PROJECT NO. PR-2021-006070

Application No. SI-2021-01889

Memorandum

Re: Westpointe40 North Site Plan DRB Comment Responses (PR-2021-006070)

TITAN 150K SPEC BUILDING ALBUQUERQUE, NM	DRAWN BY pm
	CONSTRUCTION DETAILS	DATE 12-22-21
	5571 MIDWAY PARK PL NE ALBUQUERQUE, NEW MEXICO 87109 (505) 858-3100 www.tierrawestllc.com	DRAWING 2020088-150K.DWG
RONALD R. BOHANNAN P.E. #7868	SP-2	SHEET #
		JOB # 2020088

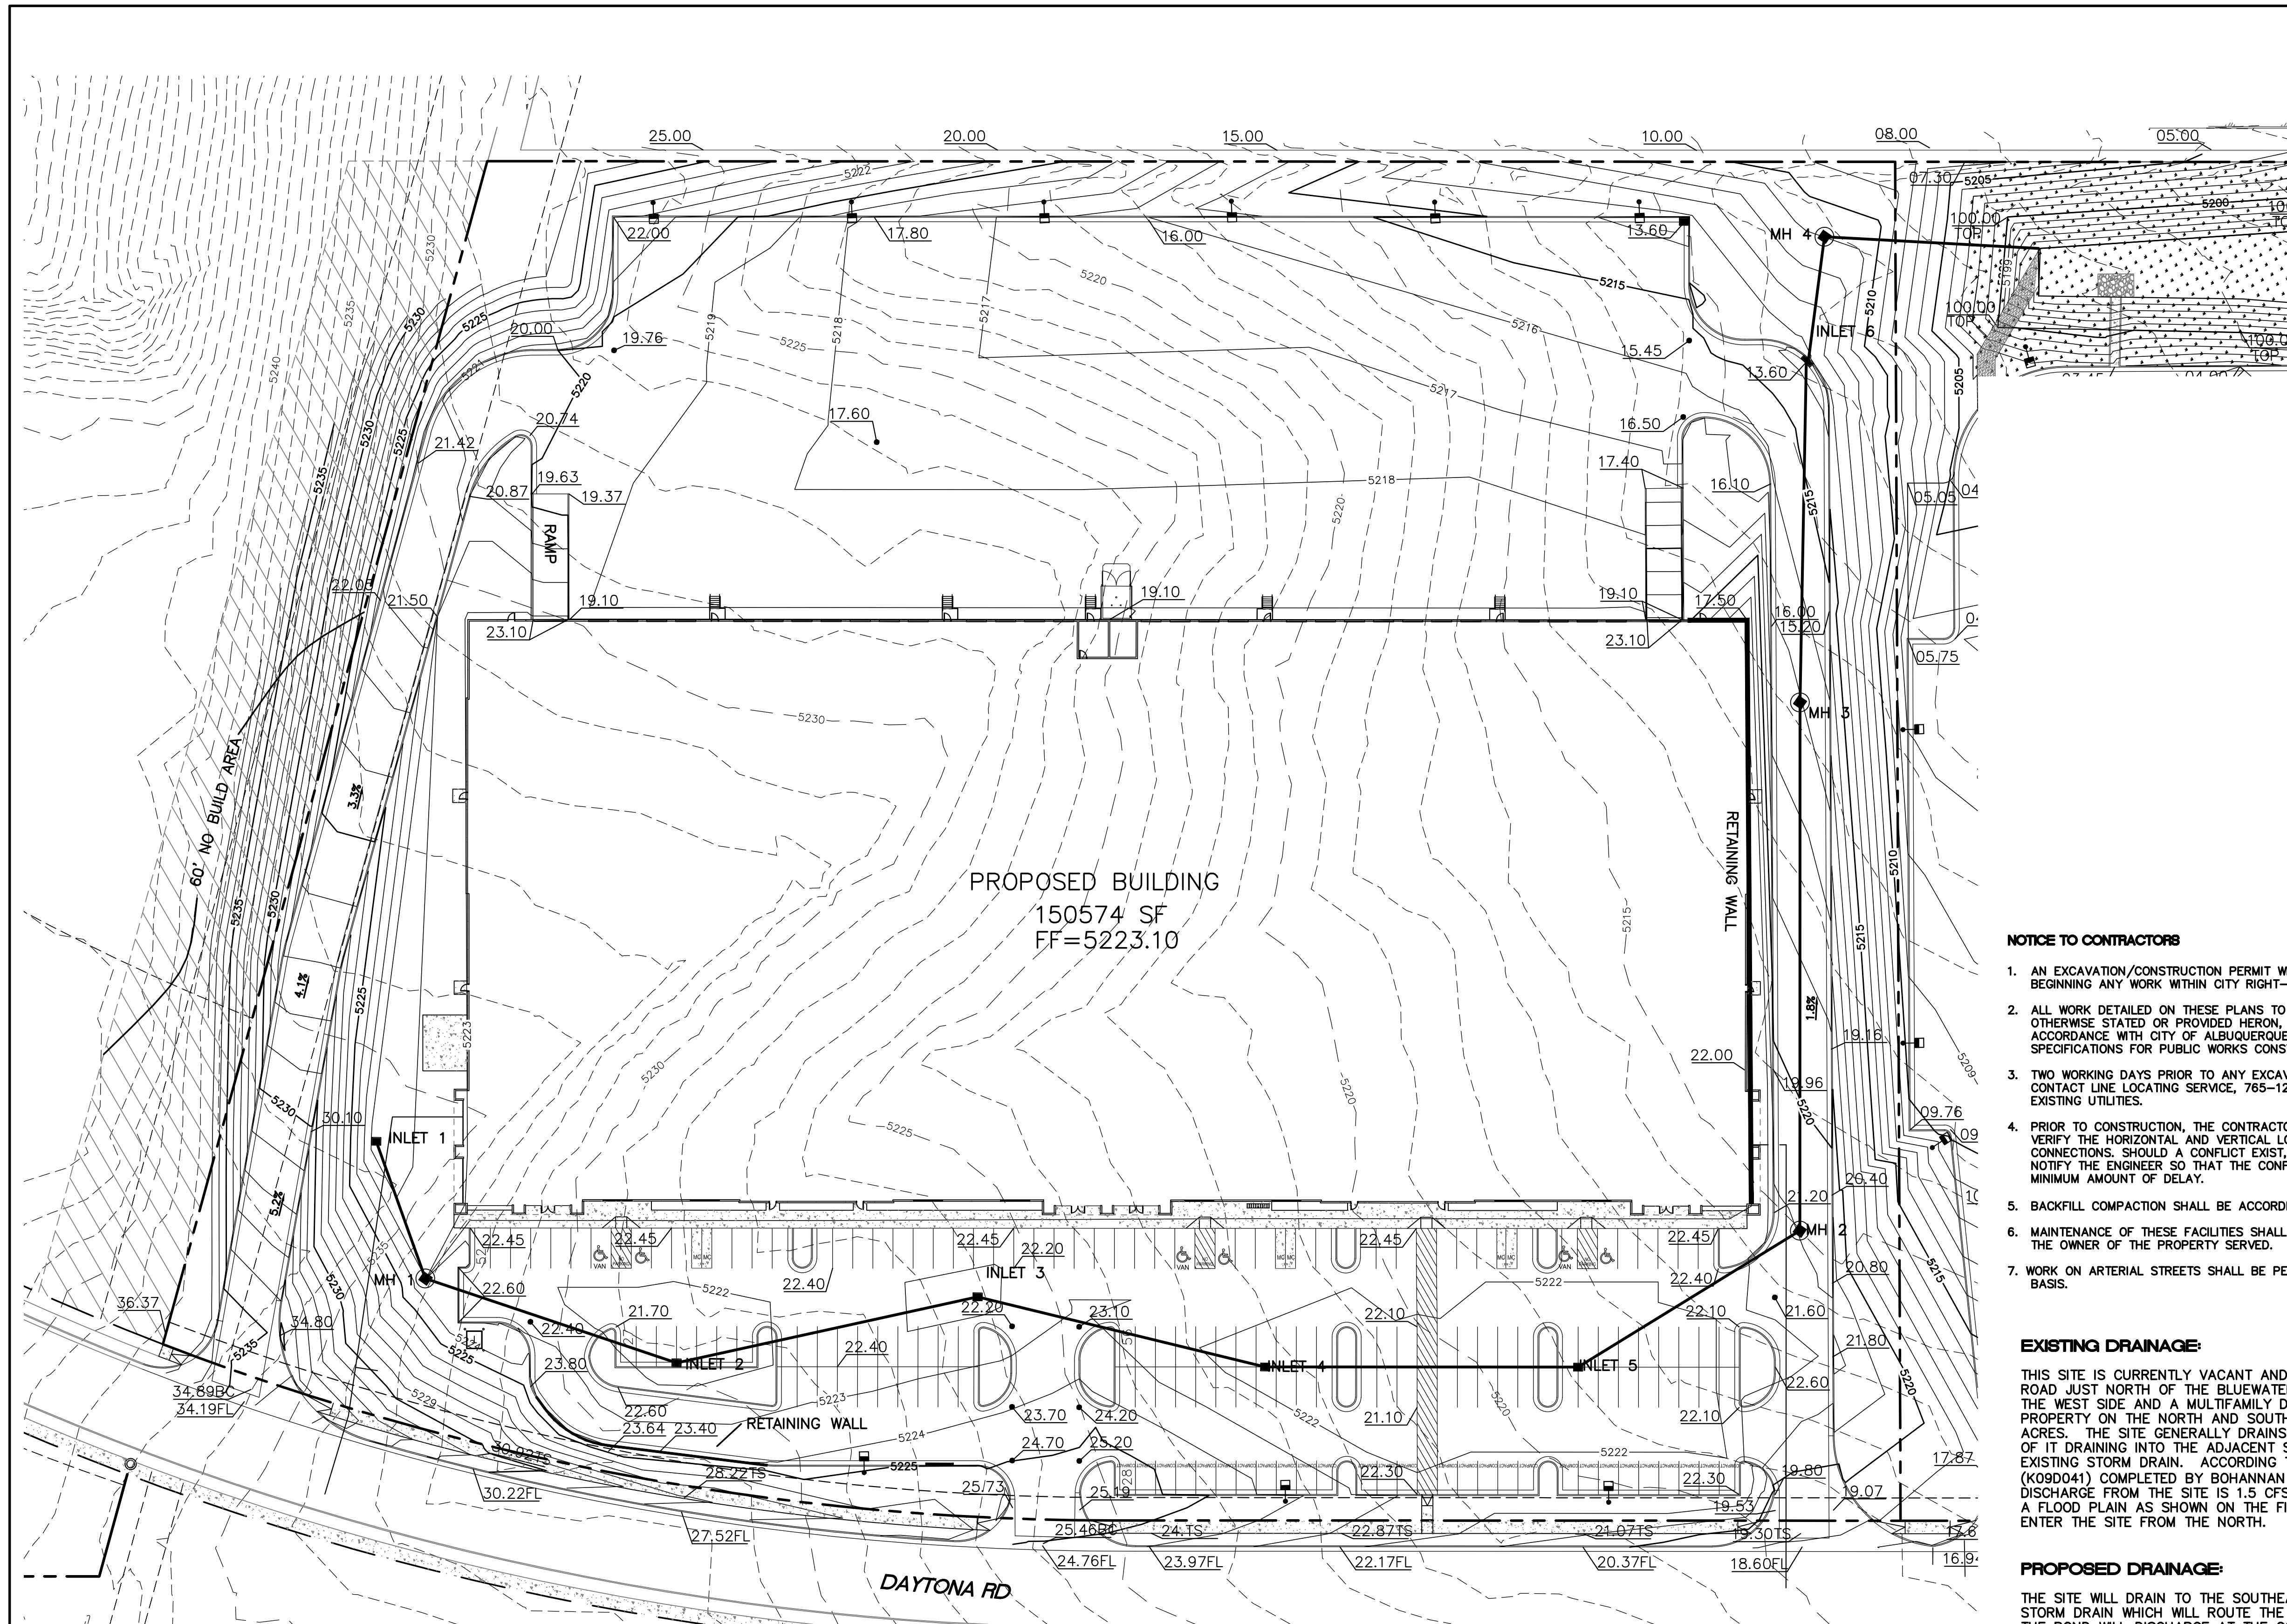
5. Include the sidewalk details on the Det-1 sheet provided. Specify the 2% maximum cross-slope on the sidewalk.
 - *The details sheet has been updated to specify the cross slope.*
6. On the curb ramp detail for van accessible aisle provided, include dimensioning, or specify minimum required dimensions for both the ramp and area between the ramp and building.
 - *A note has been added to the accessible parking/curb ramp detail specifying the minimum dimensions required between the ramp and building.*
